Planning Officer: Simon Davis

Planning Application Ref: AW/43/18/OUT

Location: 261 Aldwick Road, Aldwick

Description of works: Outline application with some matter reserved for the demolition of existing dwelling & erection of two pairs of semi-detached houses & associated works.

*proposed site plan*

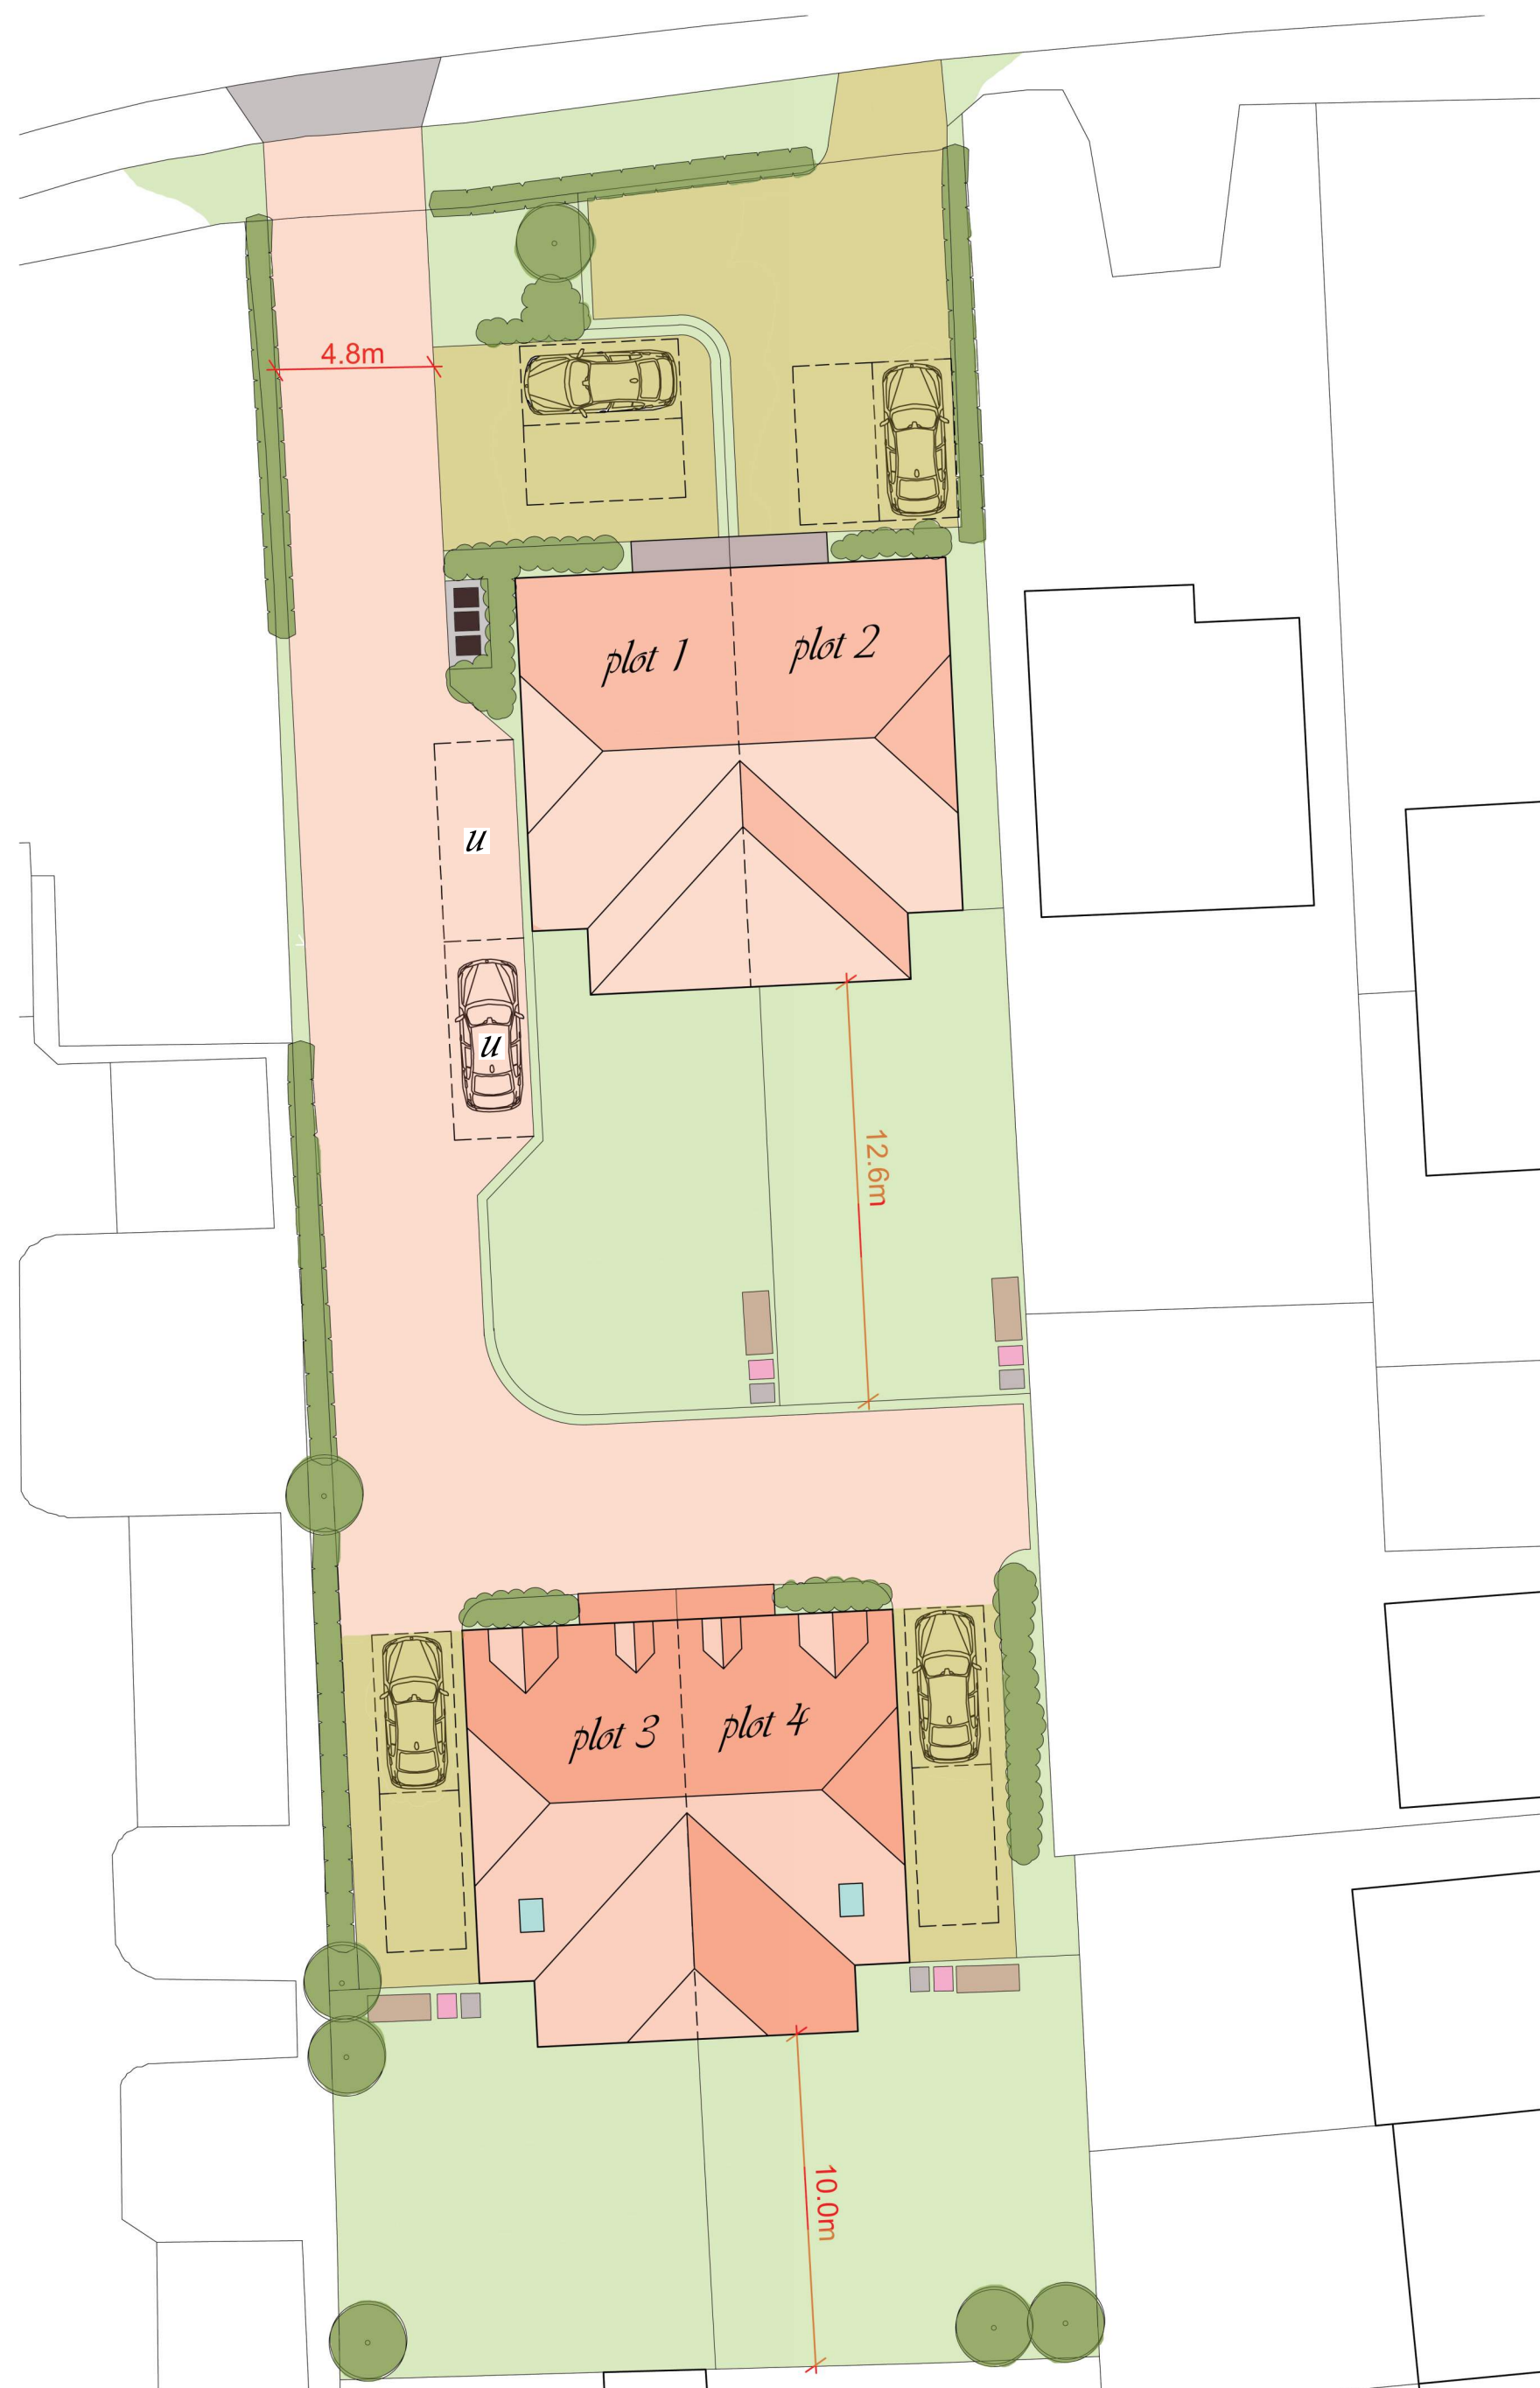
- There are substantial existing mature (probably TPO'd) trees positioned off site to the west of the application site – large Turkey Oak and an Ash & Beech tree in the grounds of Malmayne Court.
- mature Poplar in the rear garden of the property abutting to the south.
- Despite this there is no arboricultural information submitted in support of this application and the trees are not plotted on any plans or referred to at all in any text.

- The proposals will in my opinion be harmful to the vigour and vitality of trees of significance and value in the landscape – possibly resulting in their subsequent instability or demise.

- As things stand and in the absence of any supporting arboricultural information and the perceived significant threat to their future even if one had been submitted I would have to register an **OBJECTION** to this scheme.
- **IF** these tree are not already TPO'd then they should be and I would be prepared to fill out TEMPO's if necessary to support the imposition of same to afford these trees full protection.

- The applicants will need to employ the services of an Arboricultural Consultant to carry out a tree survey exercise and then prepare an **Arboricultural Impact Assessment** to support this Outline Application inclusive of a Tree Survey Schedule a Root Protection Area Schedule and a **Tree Constraints Plan** with the trees accurately plotted on same.
- In the event that RPA of any tree which is proposed for retention overlaps the development then BS5837:2012 requires that the Detailed Planning Application is accompanied by an **Arboricultural Method Statement Report** including a Tree Retentions & Removals Plan and also most importantly a **Tree Protection Plan** – to both describe and illustrate the mitigation measures which are to be employed to ensure that the trees survive without detriment to their vigour and vitality and are given adequate protection both above and below ground.
